Reference: [REDACTED]
Customer reference: EN0110013

Written submission regarding project team's comments in Issue Specific Hearing 1, their groundwater model and a model sent by the Environment Agency

The Drovers Solar Farm

DRAWING TITLE:
Figure 12.13: Work No. 2 Maximum Potential Foundations and Groundwater Elevations

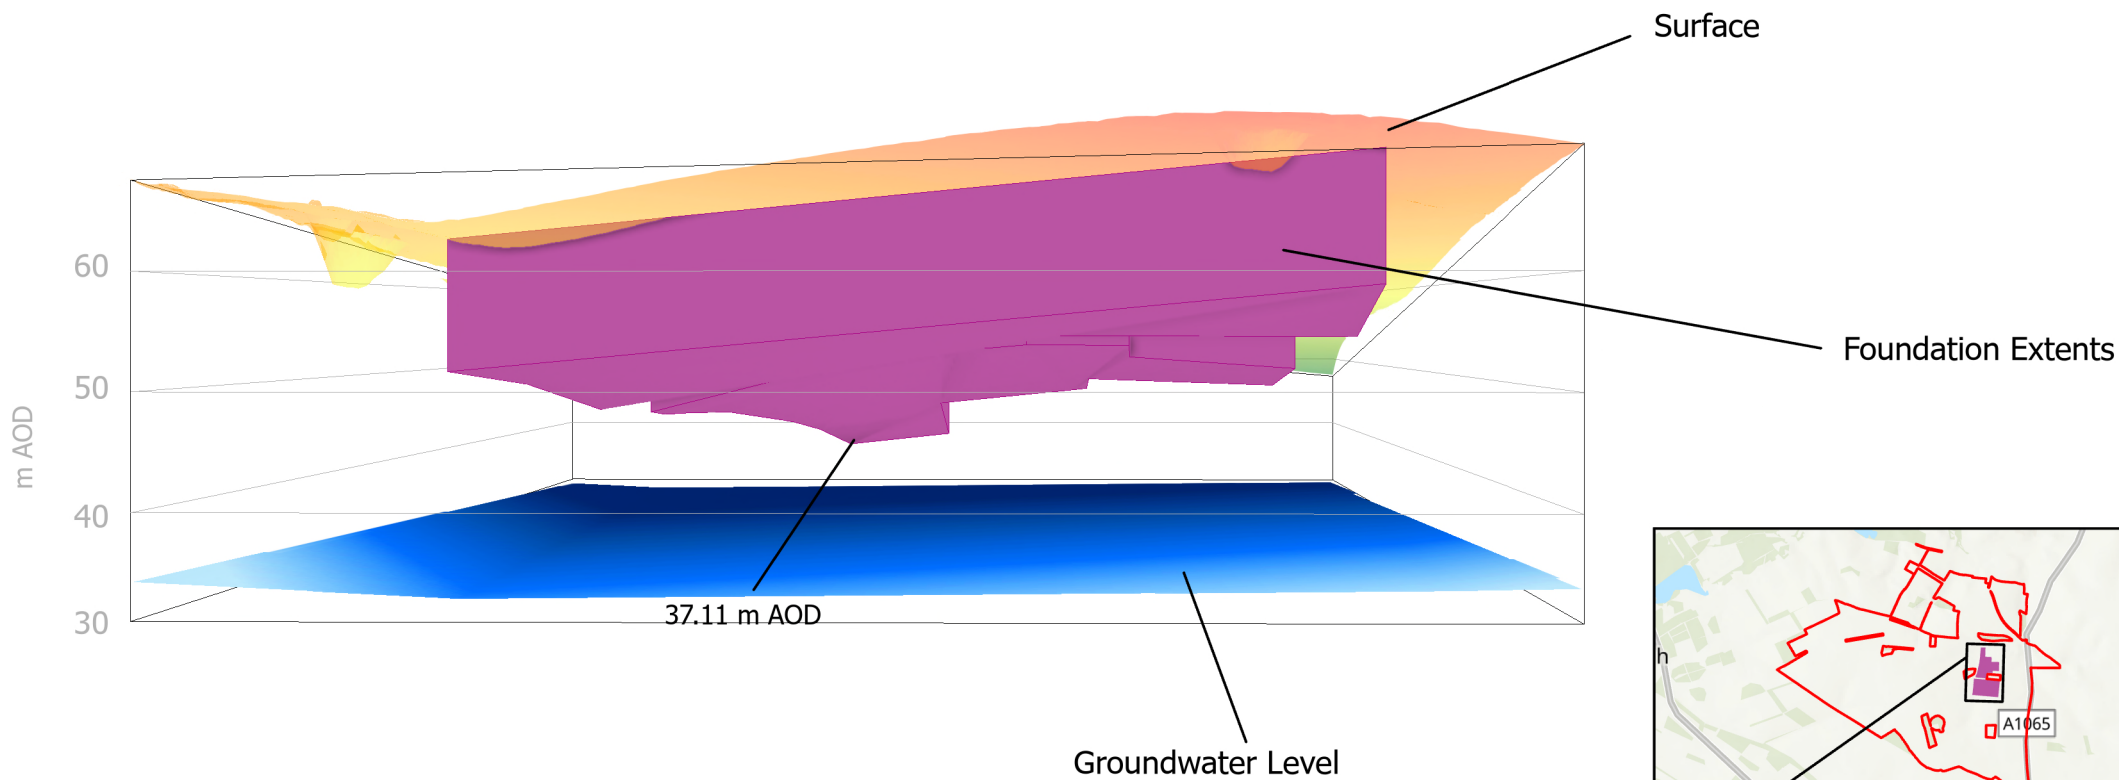
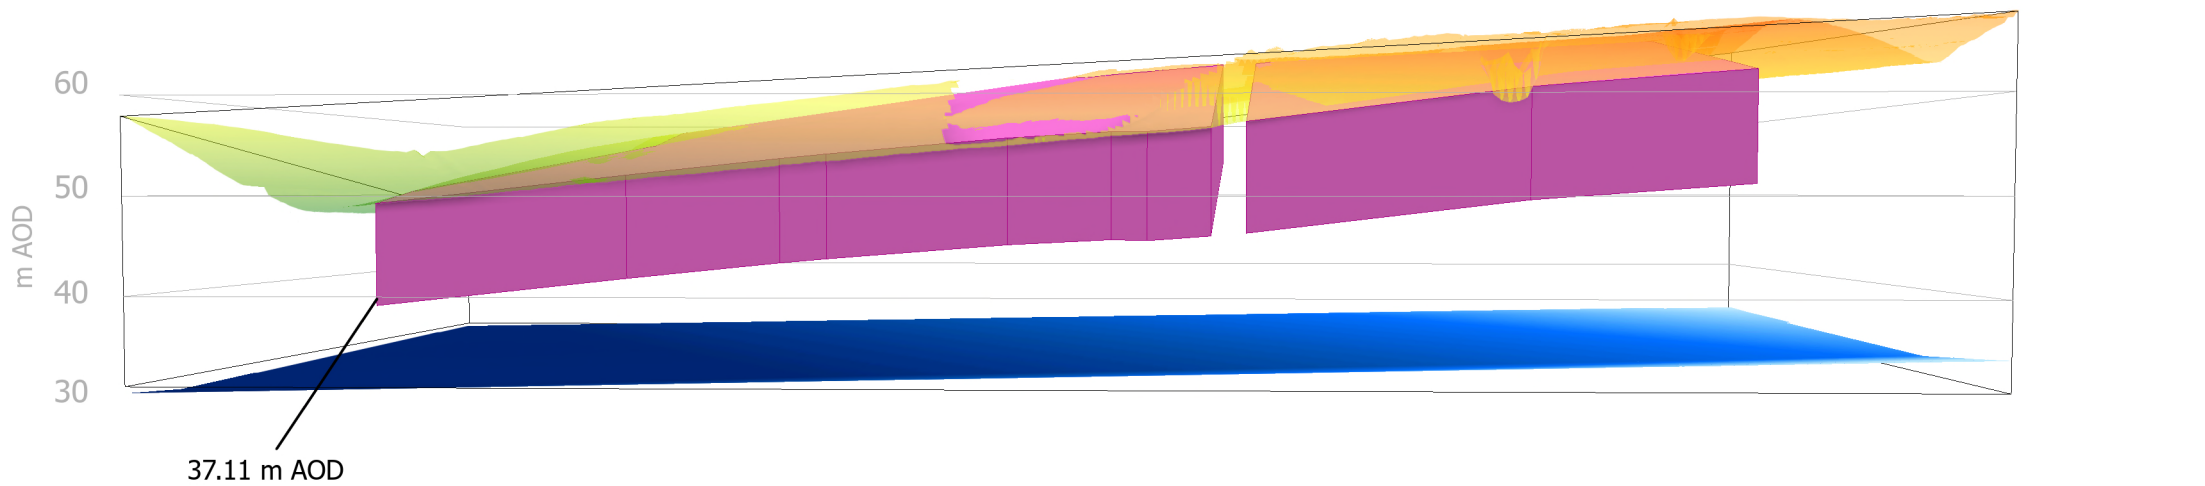
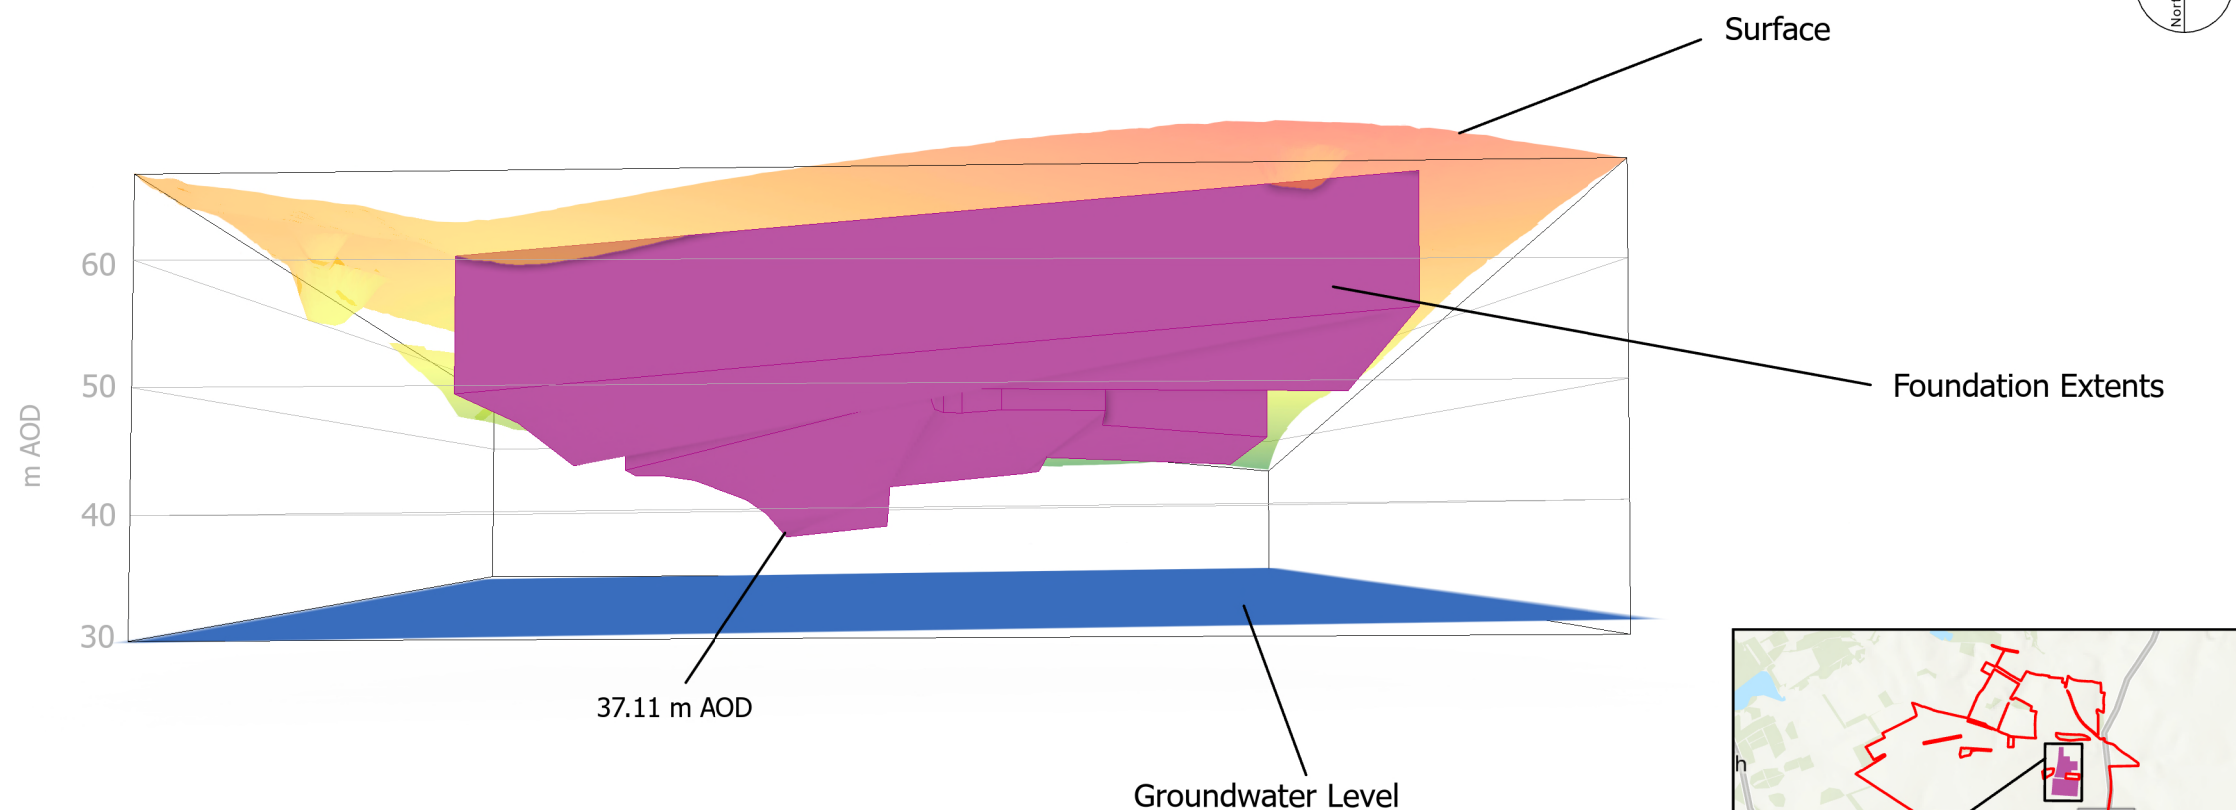
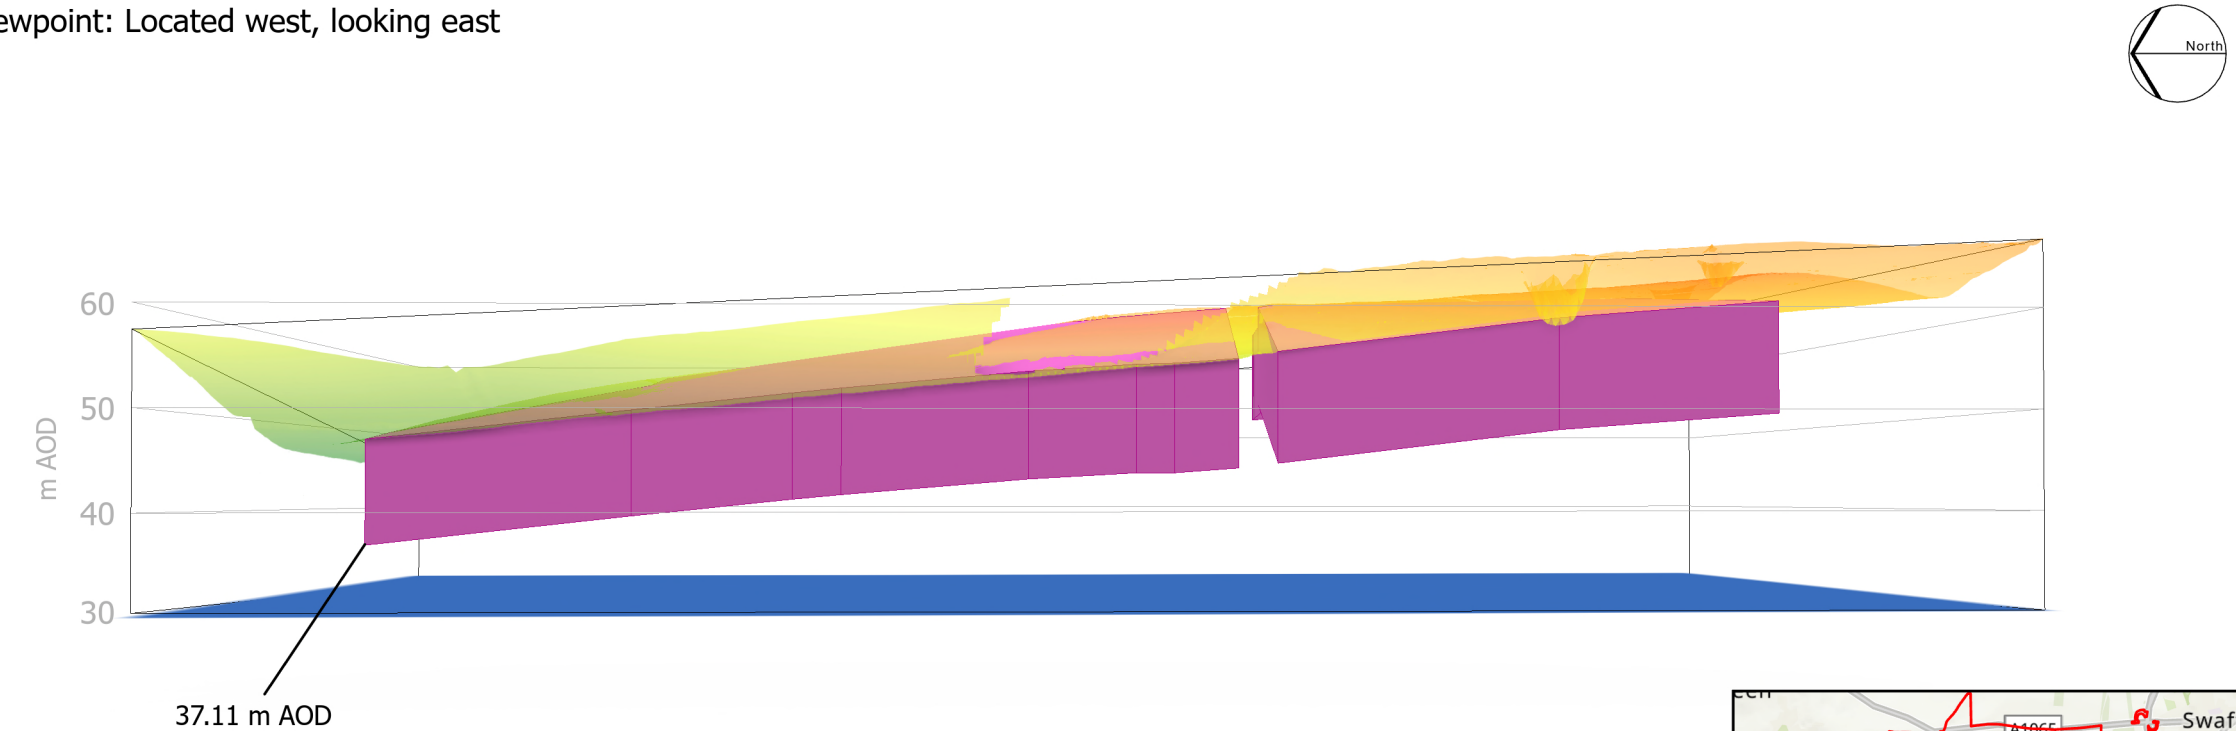
Within our relevant representation ([AS-062/RR-021](#)), we raised concerns regarding the accuracy of the hydrogeological model. In summary, our key issue was that the low resolution of the hydrogeological model may contradict other lines of

Evidence. The implication of this is that interactions with groundwater may not be fully understood. We advised that the Applicant could submit an Environmental Information Request to the Environment Agency, to check for any other hydrology monitoring stations within the Study Area and the Environment Agency's North East Anglia Chalk model. Both approaches would help to inform and check the Applicant's hydrogeological site conceptual model.

Following Issue Specific Hearing 1, in correspondence with the Applicant, we have requested that the Applicant produces a technical note summarising their review of groundwater model data provided by the Environment Agency and any implications for their hydrogeological model for the Proposed Development. The Applicant proposed to update Chapter 12: Water Resources at Deadline 2 to compare the North East Anglia Chalk model results (wet day) with the groundwater elevations

In the absence of site-specific data, even if the Applicant can demonstrate that their own model is more conservative than the North East Anglia Chalk Model, uncertainties will remain which would have to be addressed by post-consent monitoring and design mitigation as required. We will seek assurance via appropriate commitments, secured under the Development Consent Order, that the Applicant will carry out sufficient ground investigation and monitoring post-consent. This should ensure that they are able to suitably refine their ground model and mitigate any risks should groundwater rest levels be shallower than anticipated.

derived for the triangulation analysis used in the Environmental Statement. We found this approach acceptable, and look forward to reviewing the updated document.
